BARBARICK WASTE TRANSFER STATION

VARIANCE OF REQUIRED BUILDING SETBACK
LETTER OF INTENT

Add "PCD File No. AL2310"

## SITE PLAN EXHIBIT

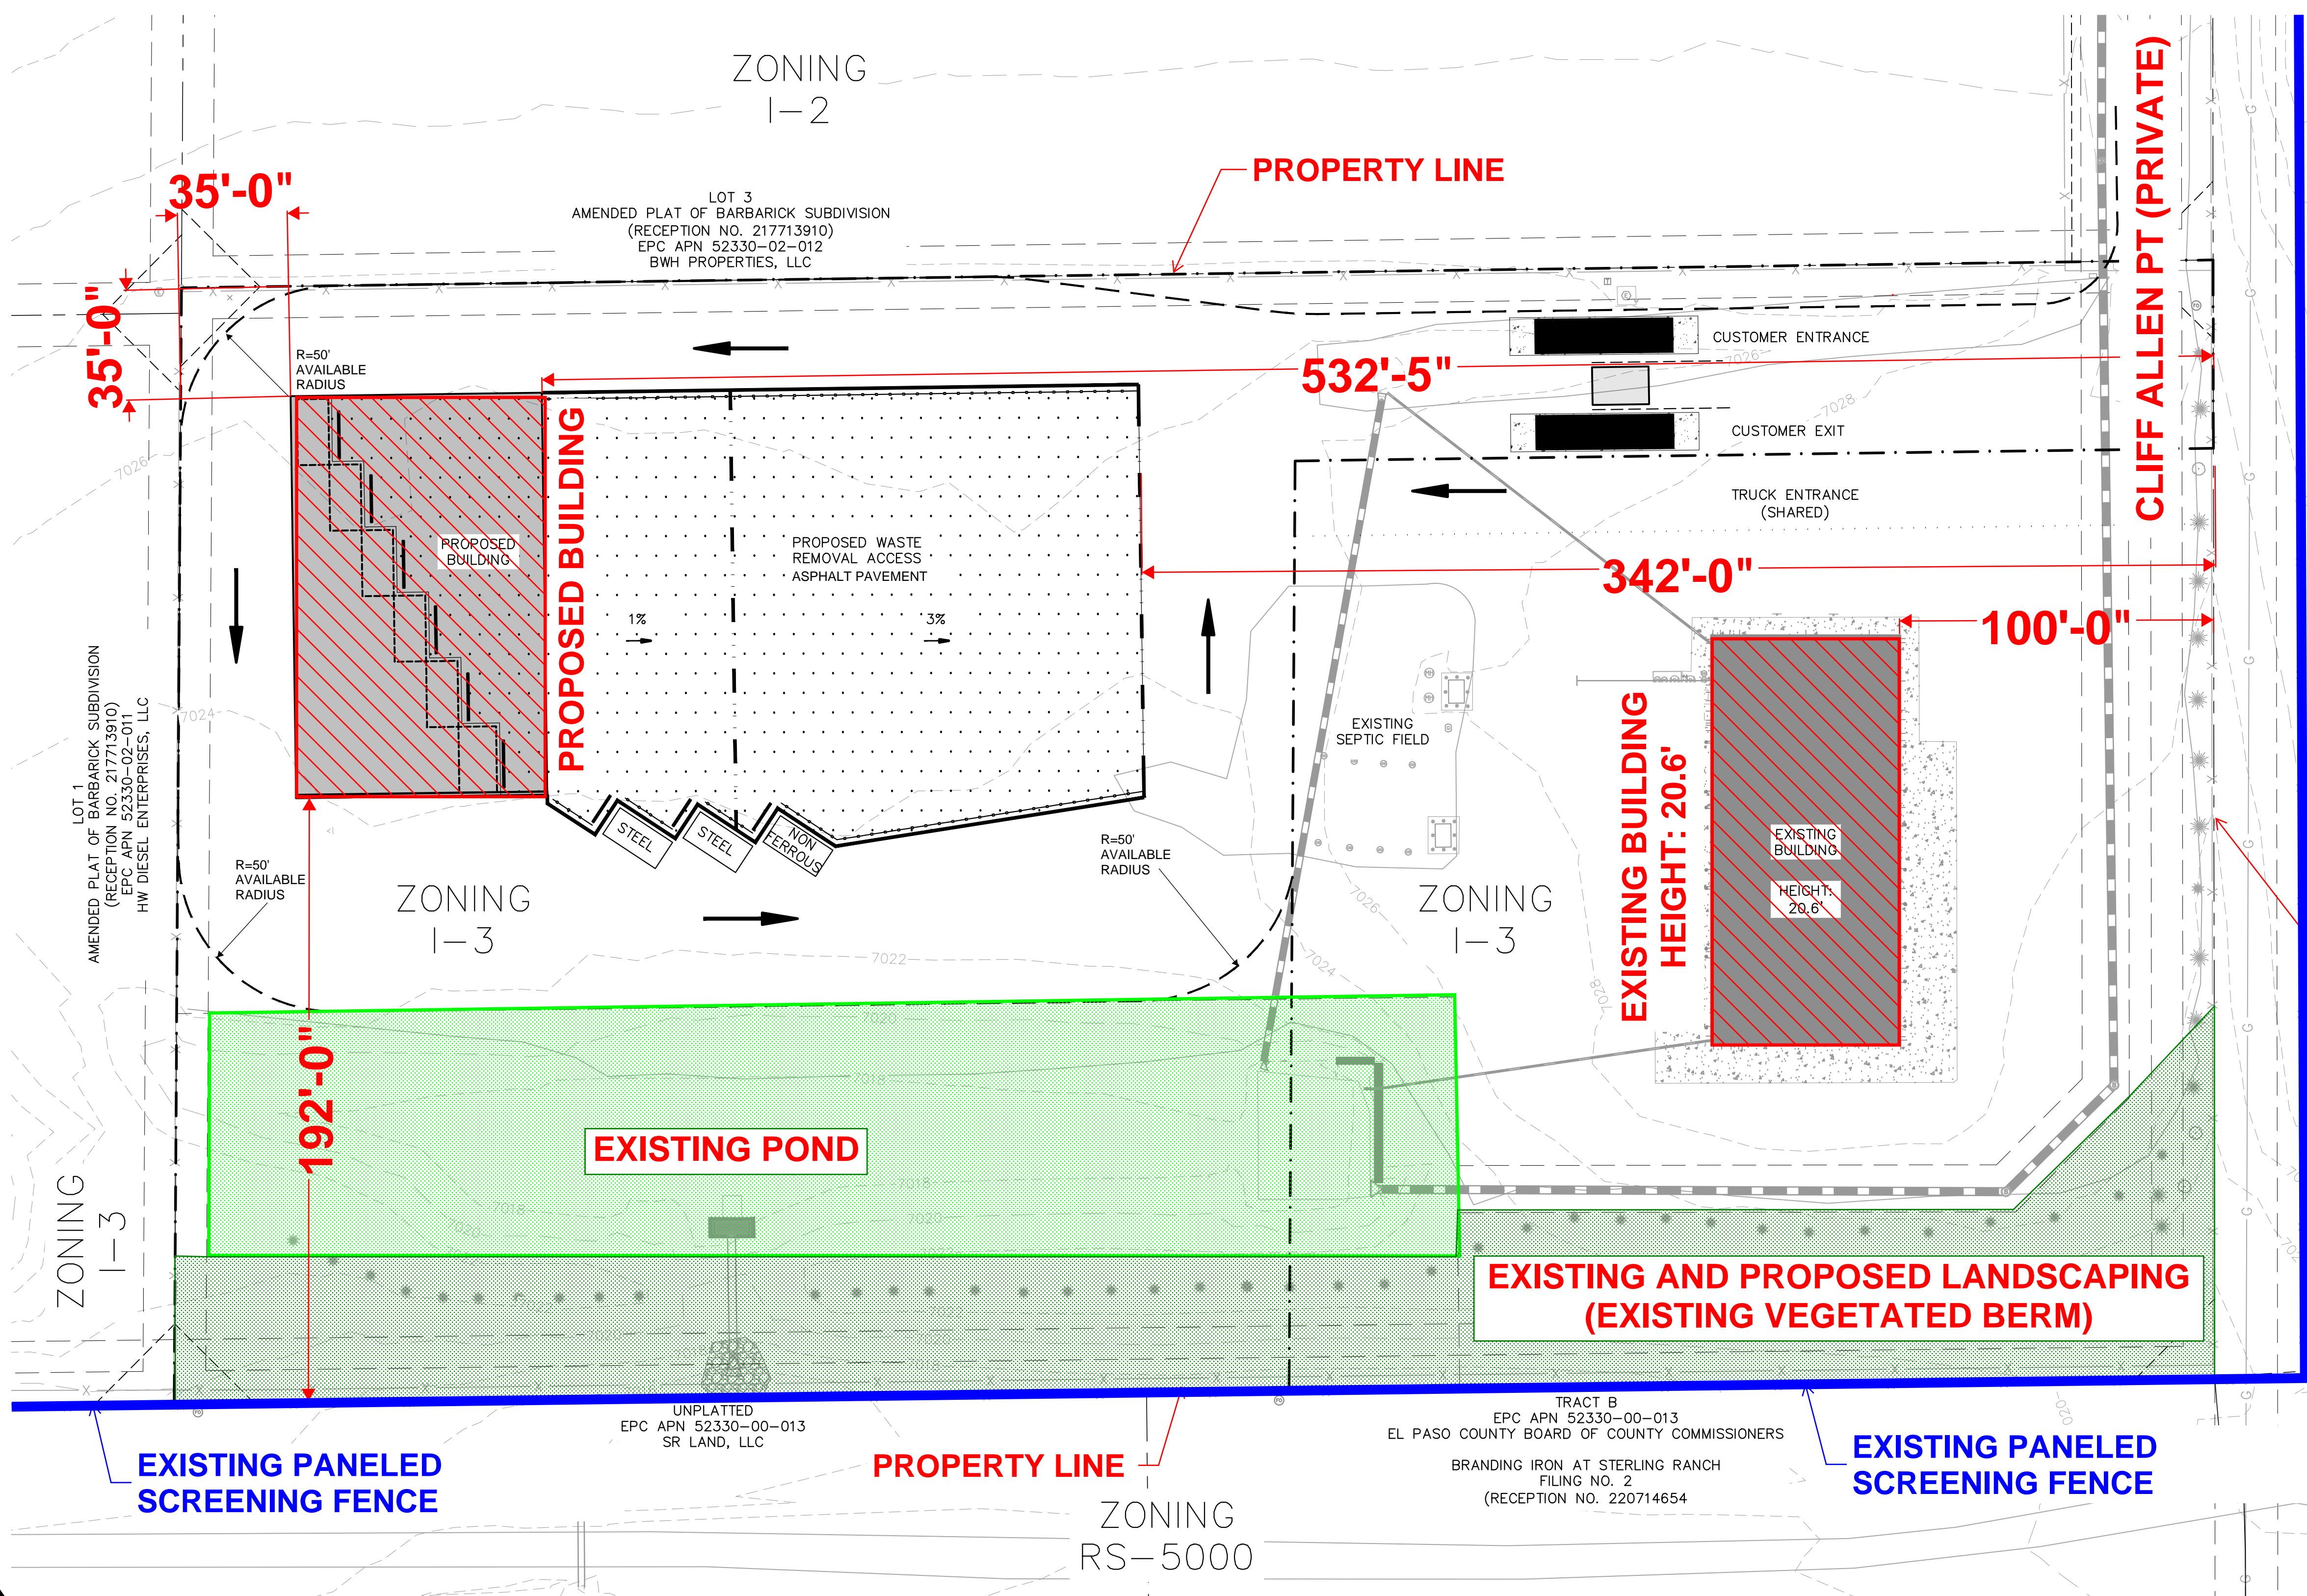
Please include:
 - dimensions and locations of property lines
 - dimensions of ROW
 - traffic circulation
 - no build, floodplain, or drainage areas
 - location and screening for dumpsters and loading areas
 - building height
 - signage? provide dimensions
 - building height
 - required vs provided parking
 - ADA parking, ramps, signs
 - location and height of outdoor illumination

Provide building dimensions and area.

KH RESPONSE:
 - Dimensions and locations of property lines and ROW included
 - Traffic circulation shown
 - no build areas shown (Property corners) and drainage easement/detention facility
 - screening is provided by the natural berm/bank of detention facility. See Site plan sheets
 - approximate building height and area has been included
 - signage for the site is not proposed at this time
 - parking is to be determined by the PCD director per 6.2.5(D)(1)(a)(ii) - Below Table 6-2 of EPC LCM.
 - All outdoor illumination for the site is to be full cut off and downwards oriented lights, installed directly to the enclosures building face. Lights are to be installed less than 15' in height from floor elevation.

BARBARICK WASTE TRANSFER STATION

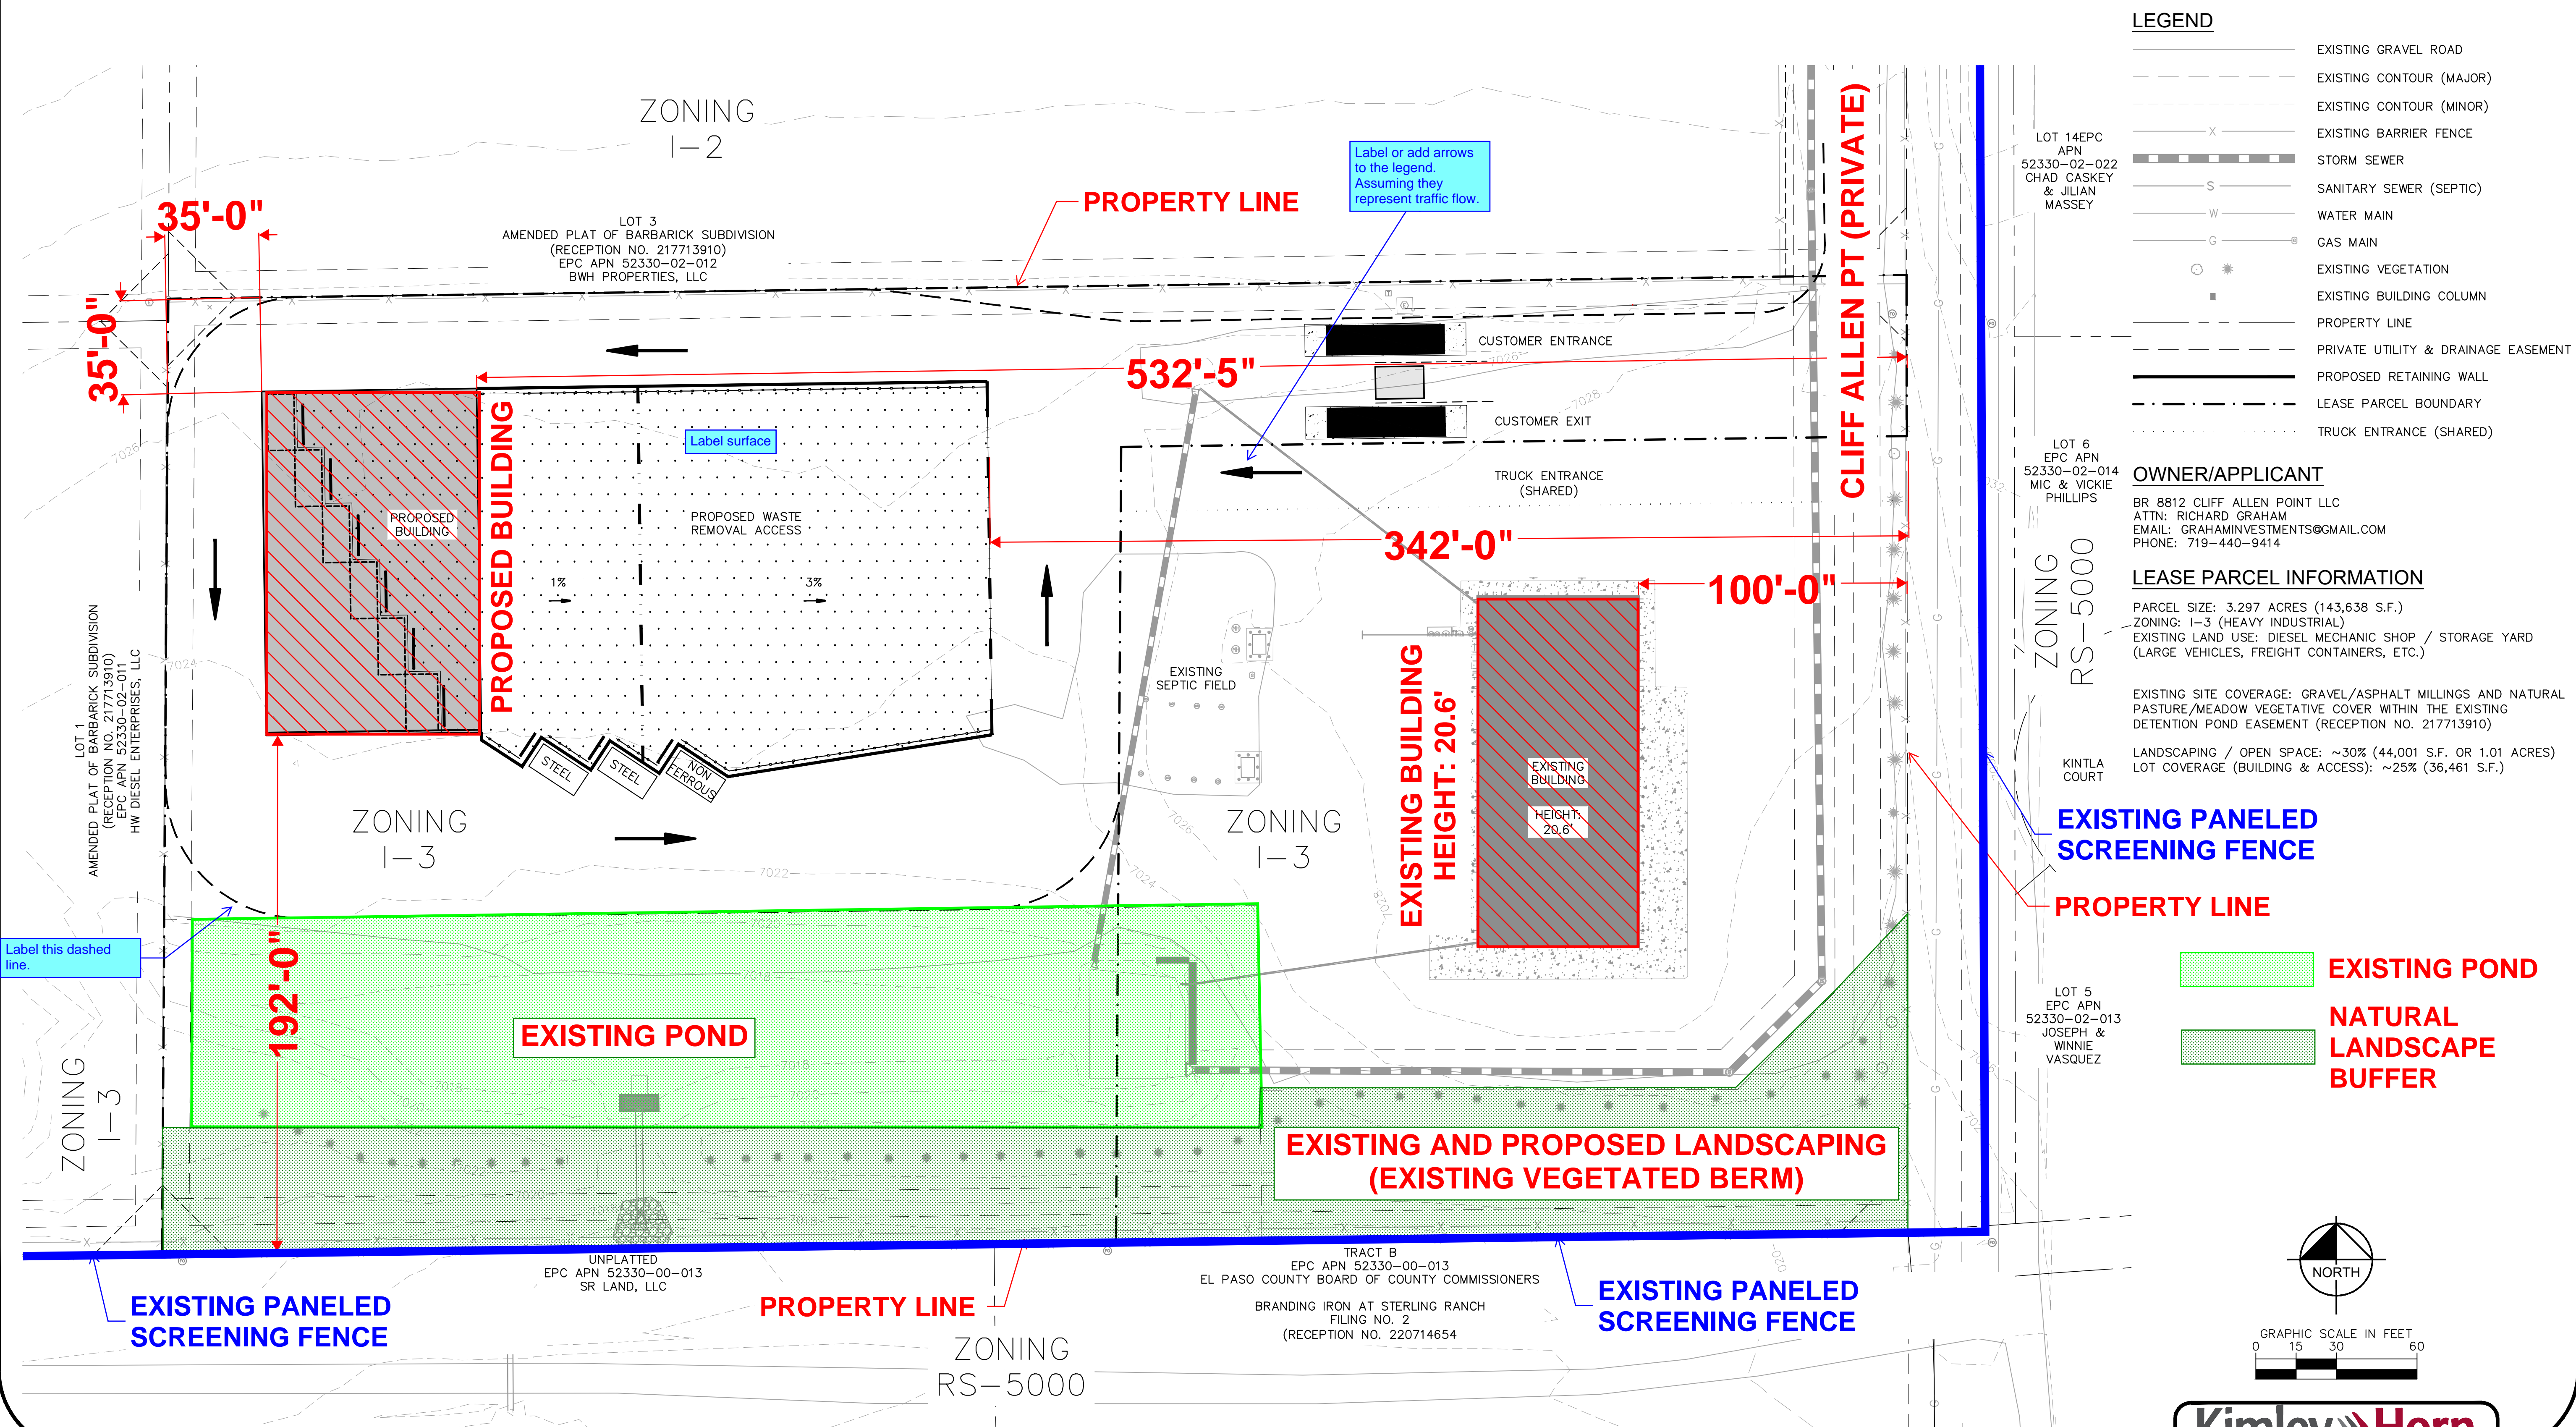
Recommend combining separate site plans

PLEASE COMBINE SITE PLANS INTO ONE DOCUMENT.

KH RESPONSE:
Combining 3d rendering - both site plans - and guardrail detail.
